City of Albuquerque
Planning Department
Development Services Division
P.O. Box 1293
Albuquerque, New Mexico 87103

OFFICIAL NOTIFICATION OF DECISION

FILE: 01128-01231 (Project 1001436)

LEGAL DESCRIPTION: Request approval of a site development plan for building permit for Lot L-1, Vista Del Norte, zoned SU-1 for O-1, located on Osuna Road NE and Edith Boulevard, containing approximately 10.25 acres. (E-16)
Lola Bird, Staff Planner

KEYED LANDSCAPE NOTES

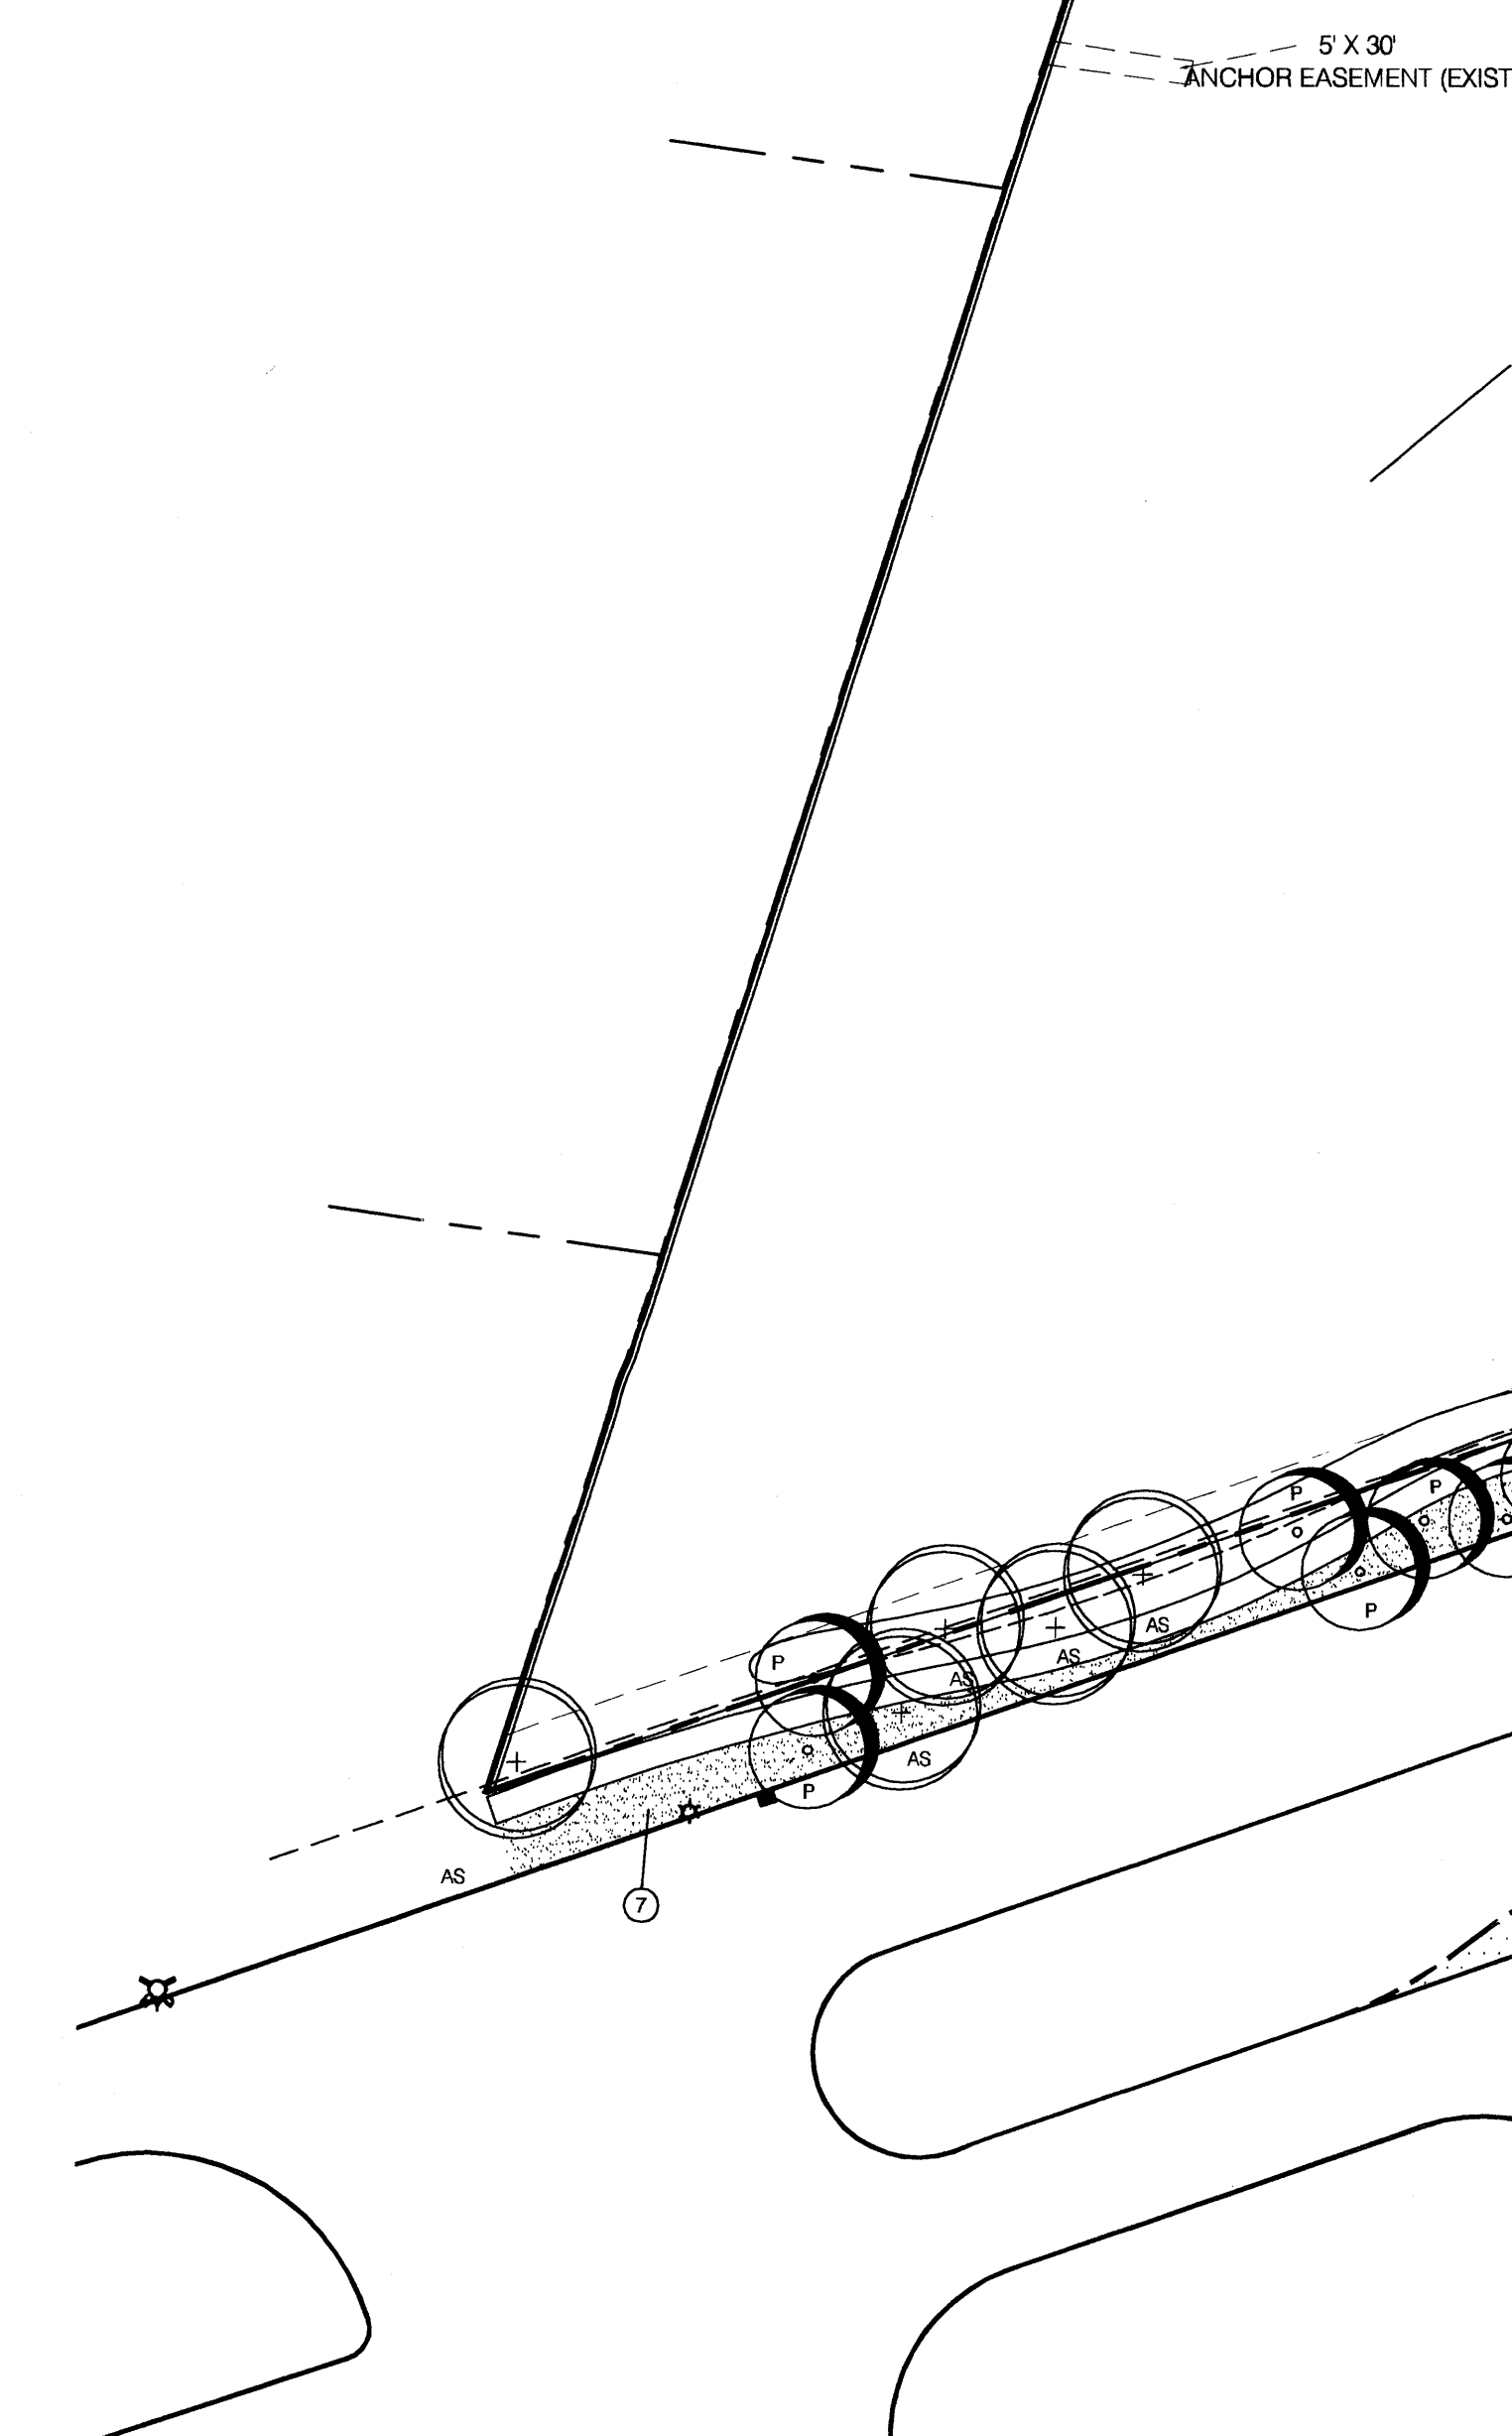
2. Landscaping:
 - a. The landscape plan shall note a reseeded of the future expansion area with a mix of sand dropseed, galleta grass and Indian rice grass and sufficient watering for the first year or two to ensure the establishment of the grasses.

- b. The landscape plan shall show one additional tree, located at the south end of the ADA accessible parking area where the pedestrian pathway from Vista del Norte connects to the building.

- c. The trees planted along the length of the building's exterior shall be located closer to the sidewalk to provide for adequate shading of the sidewalk.

- d. To comply with the Street Tree Ordinance, at least 36 trees planted within 20 feet of the edge of the street shall be shown on the landscape plan. Trees shall be planted along both sides of the meandering sidewalk.

- e. The landscape plan shall indicate a 6-month period for the installation of the landscape. The installation of the trees shall occur within 60 days of building occupancy.

SHEET TITLE: **GRADING PLAN**  
SHEET NO.: **C3.0**

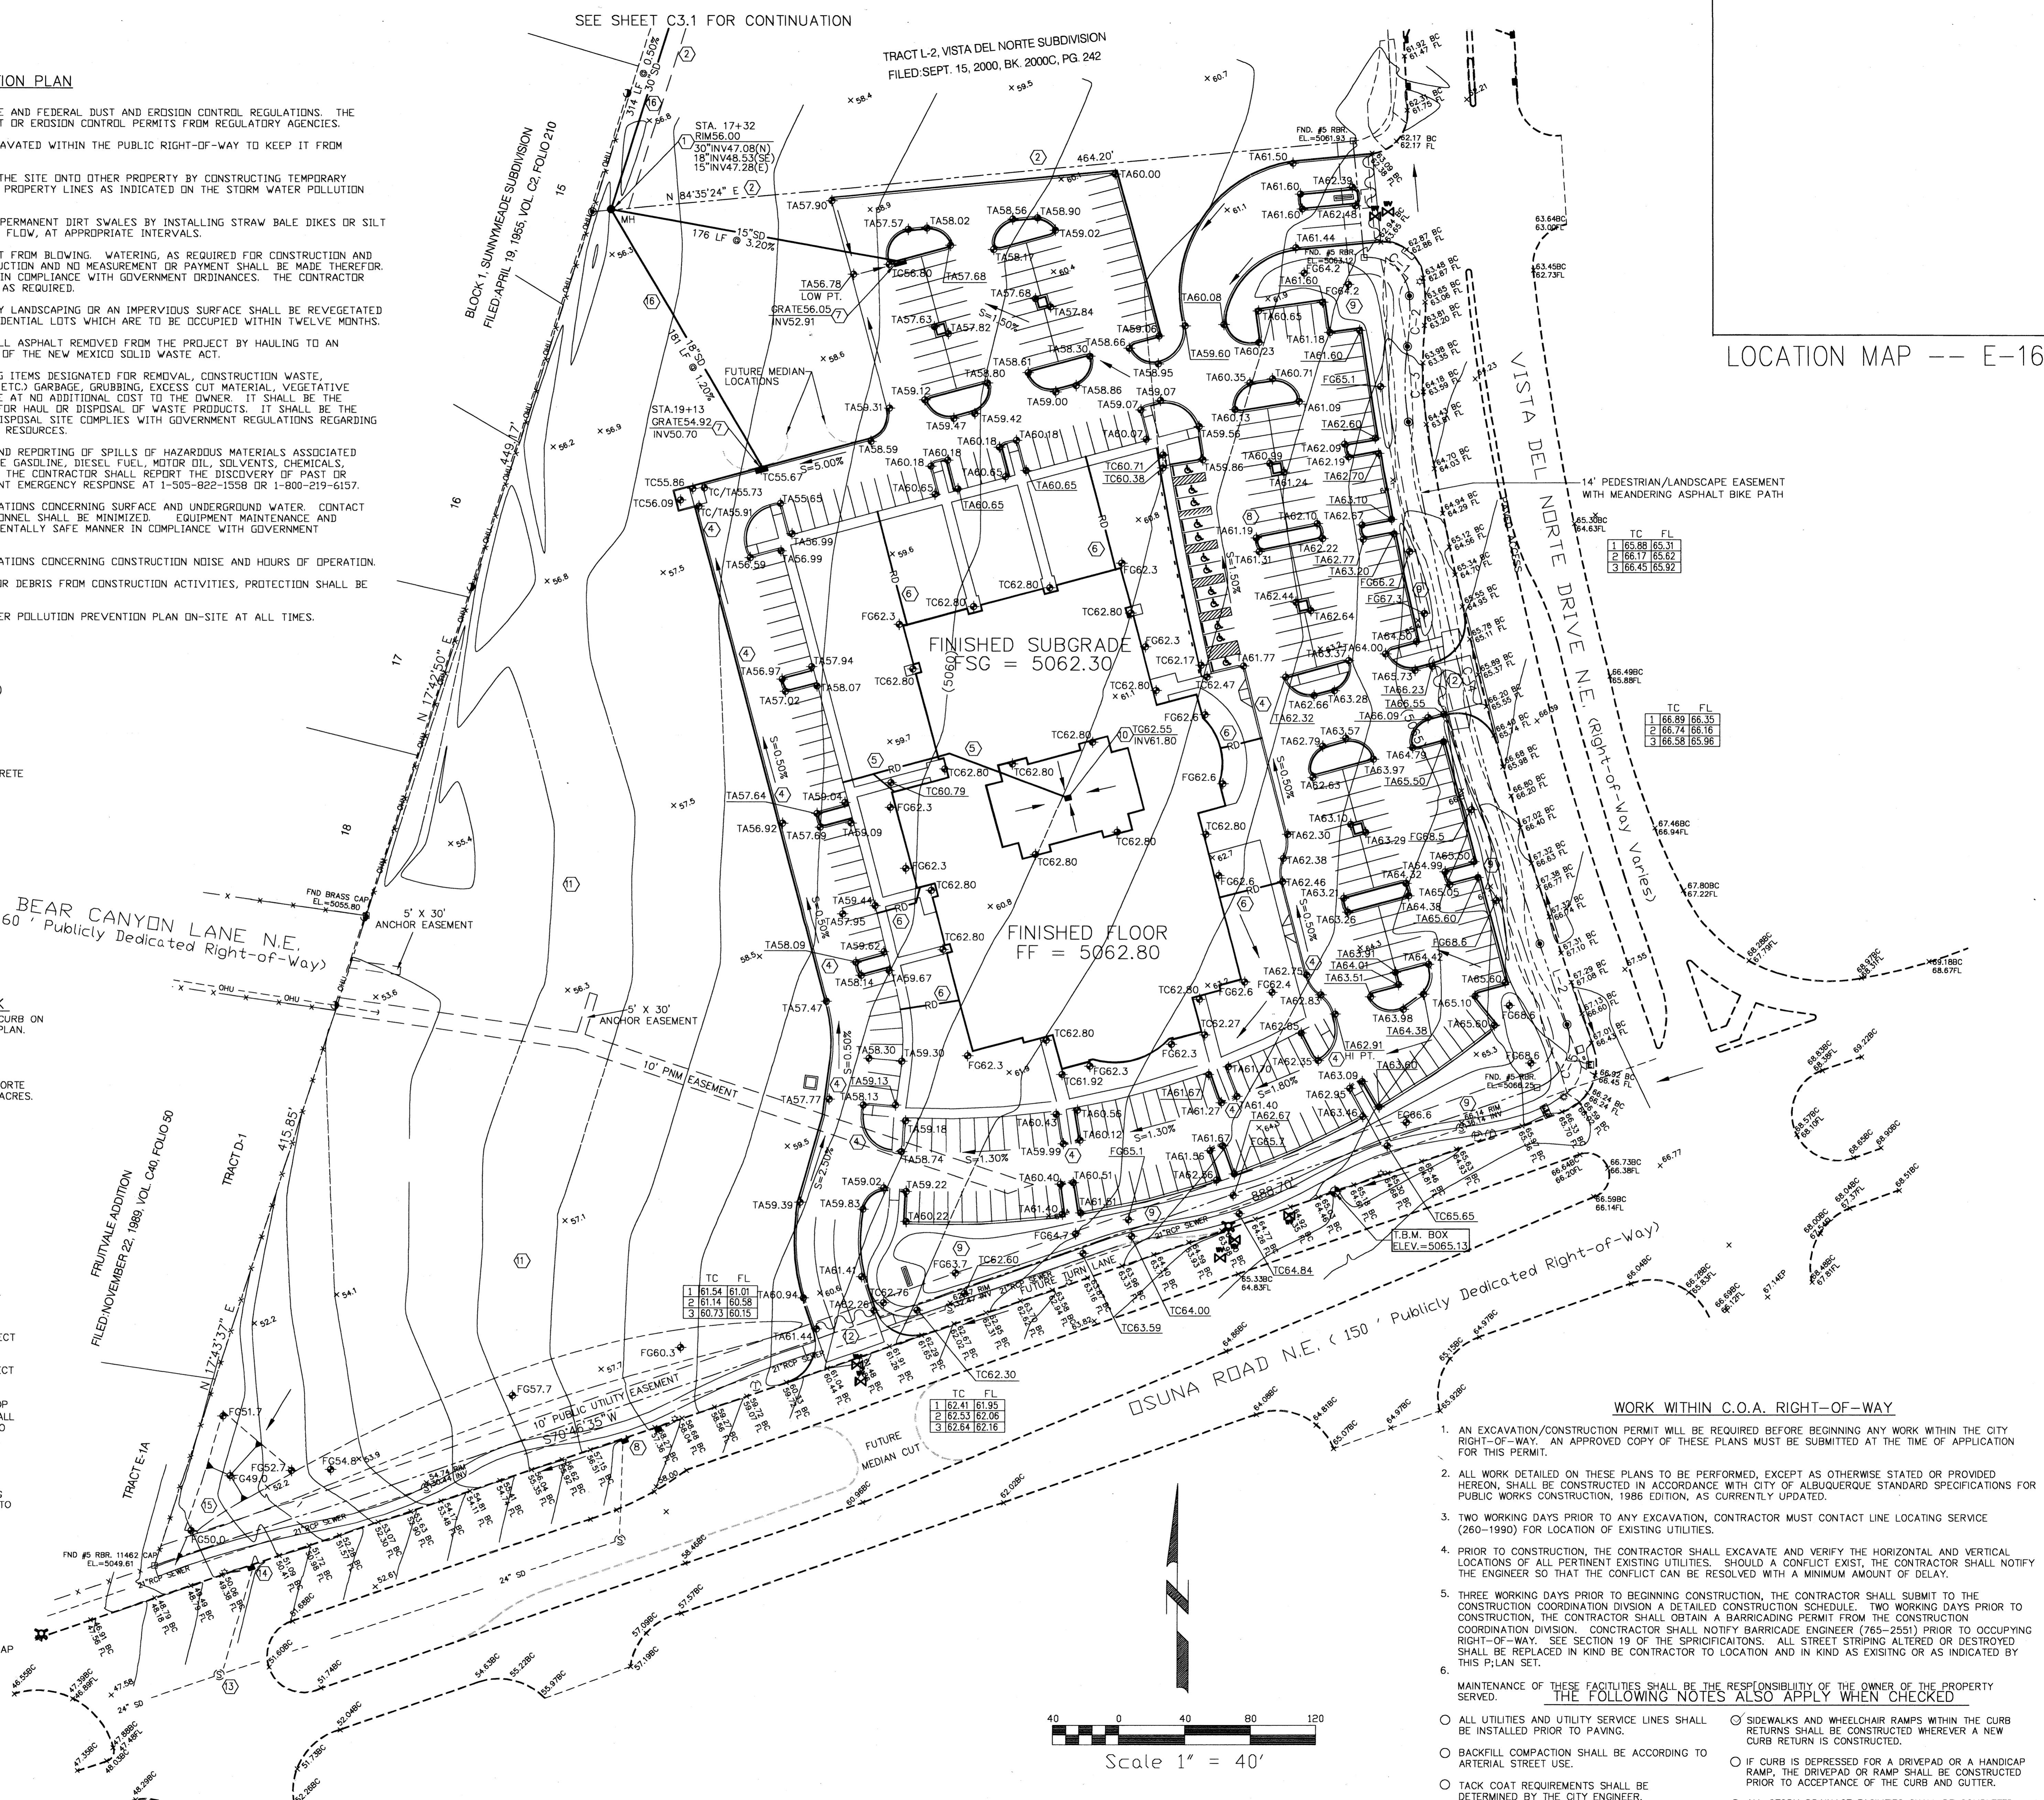
- f. Adequate access barriers shall be included so as to prevent vehicular access to the undeveloped portion of the site. An asphalt curb is acceptable.
